MASTER DEVELOPMENT DRAINAGE PLAN & FINAL DRAINAGE REPORT

MONUMENT ACADEMY

Engineering Review

**JPS Project No. 040201
PCD File No. SP-19-
PPR-19-009**

VERTICAL CONTROL POINT

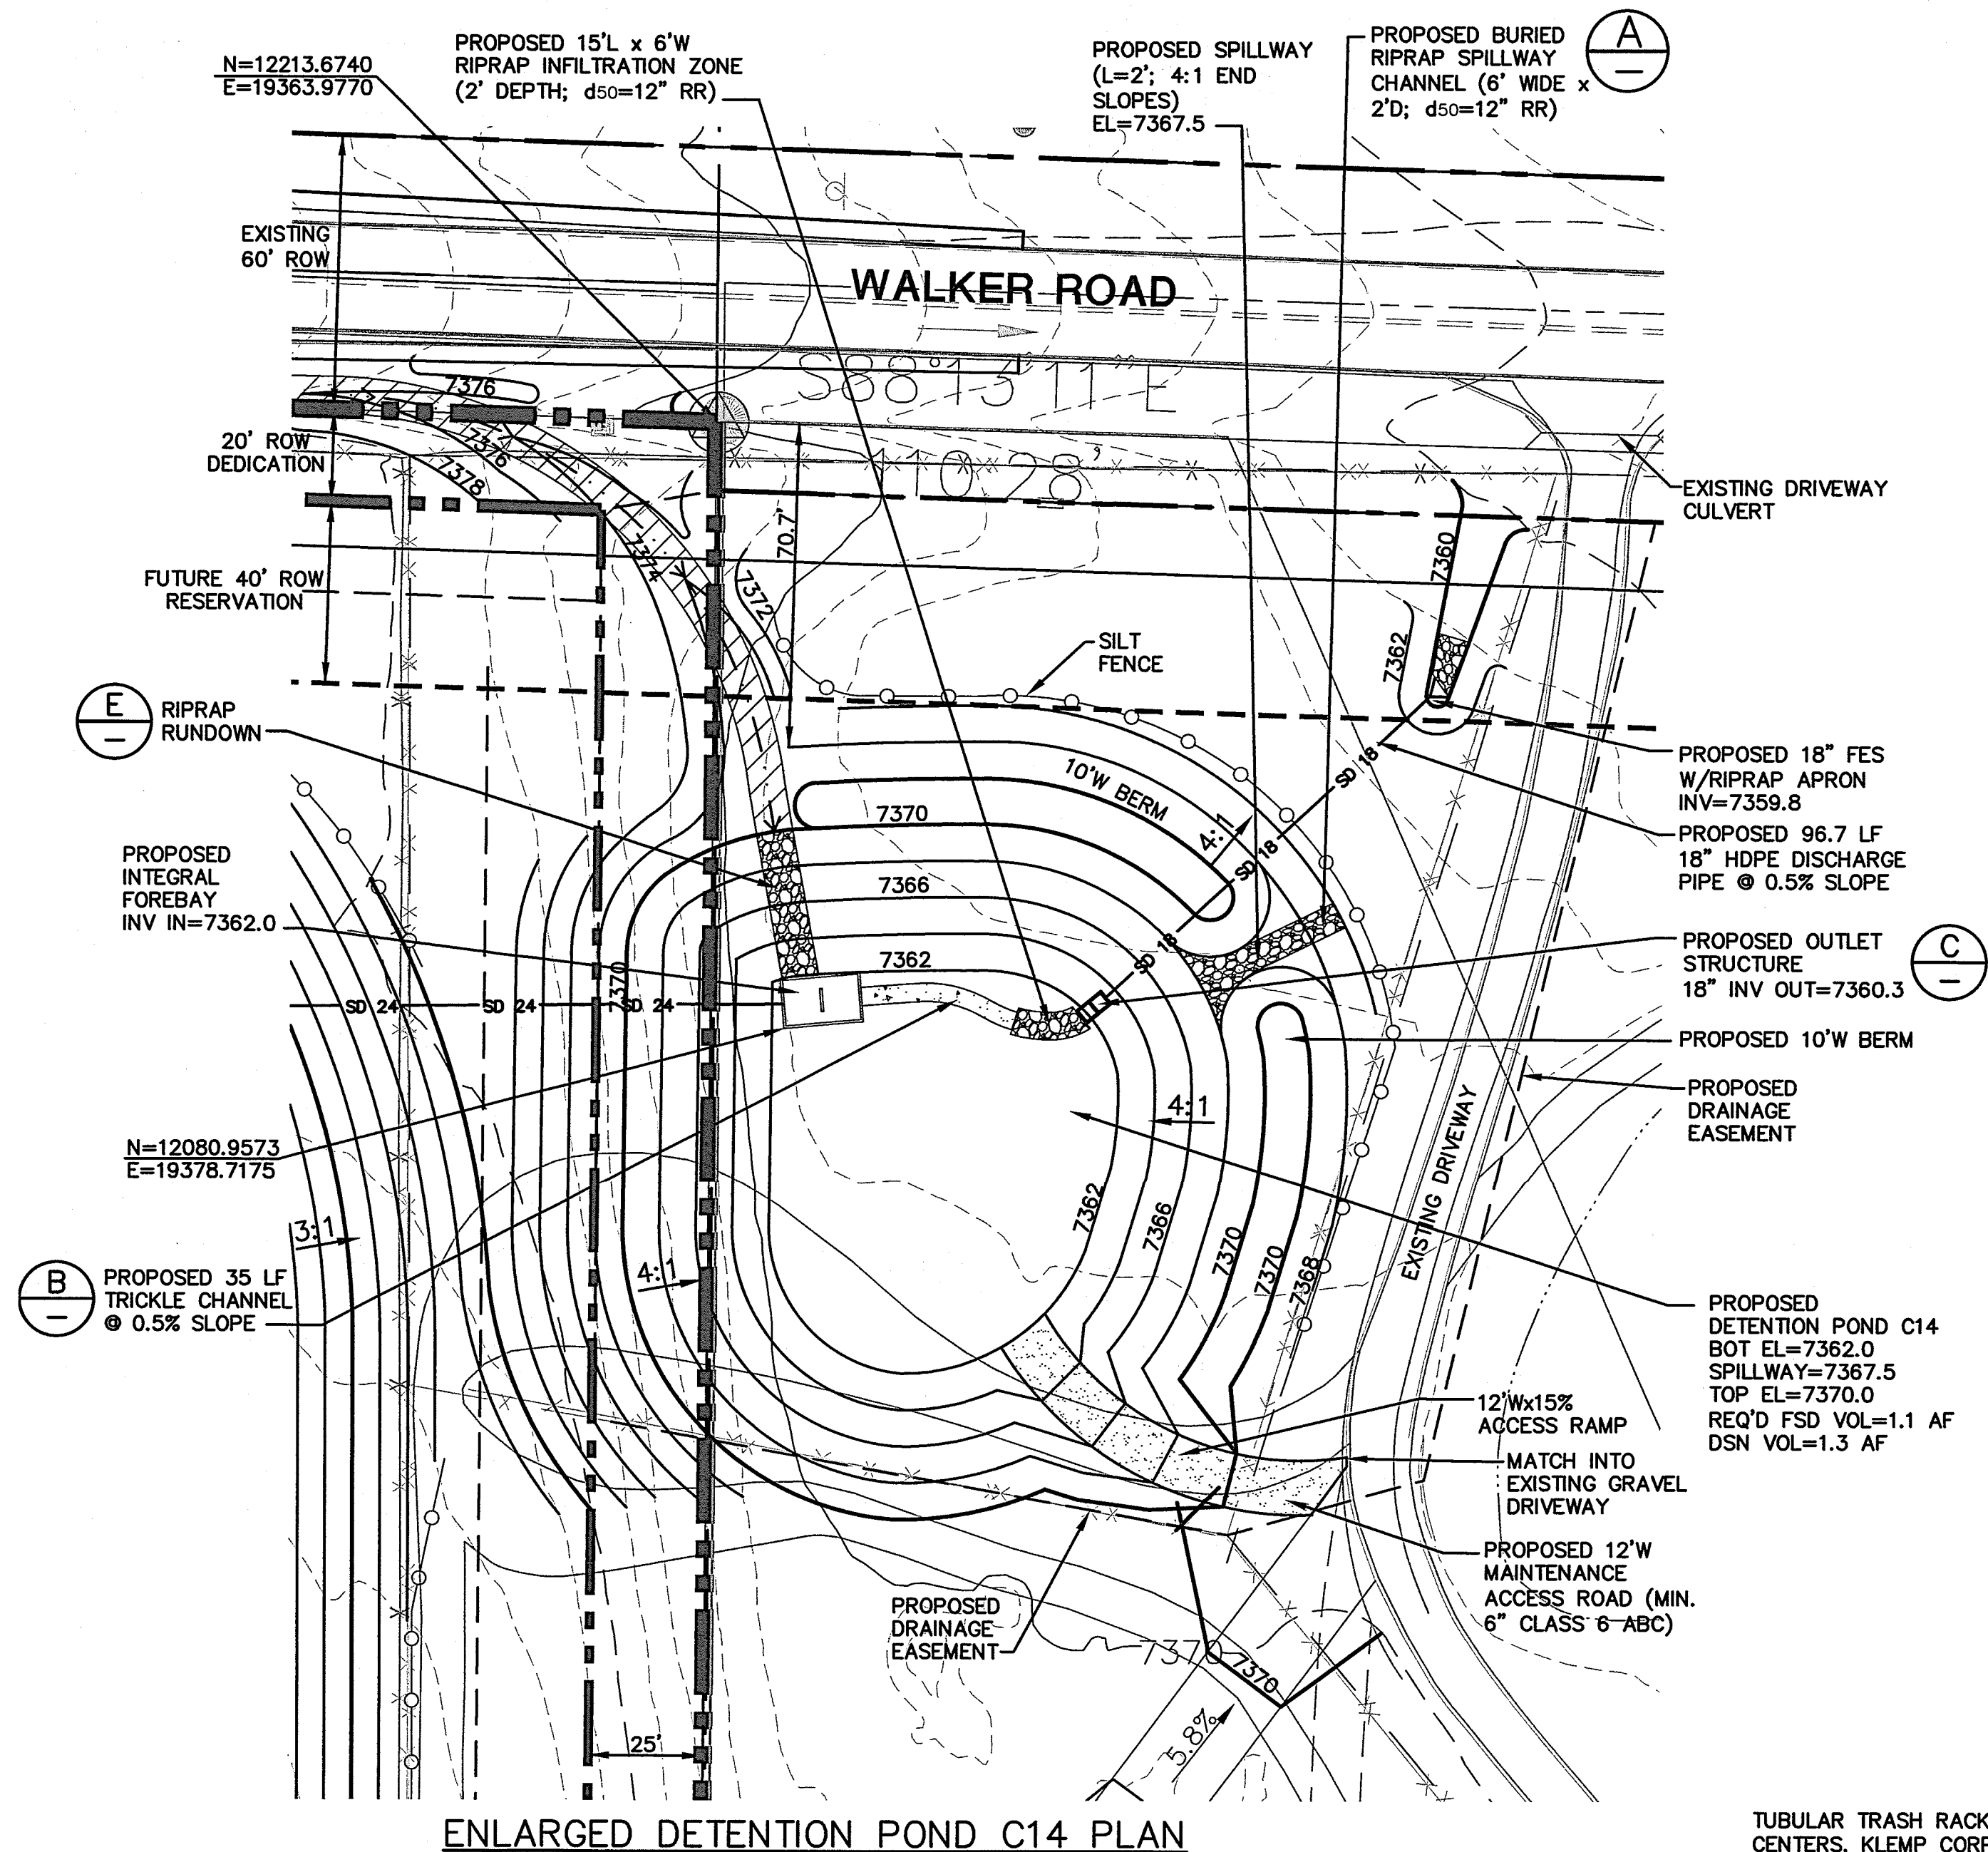
Describe pond inflow/outflow and volume attributes.
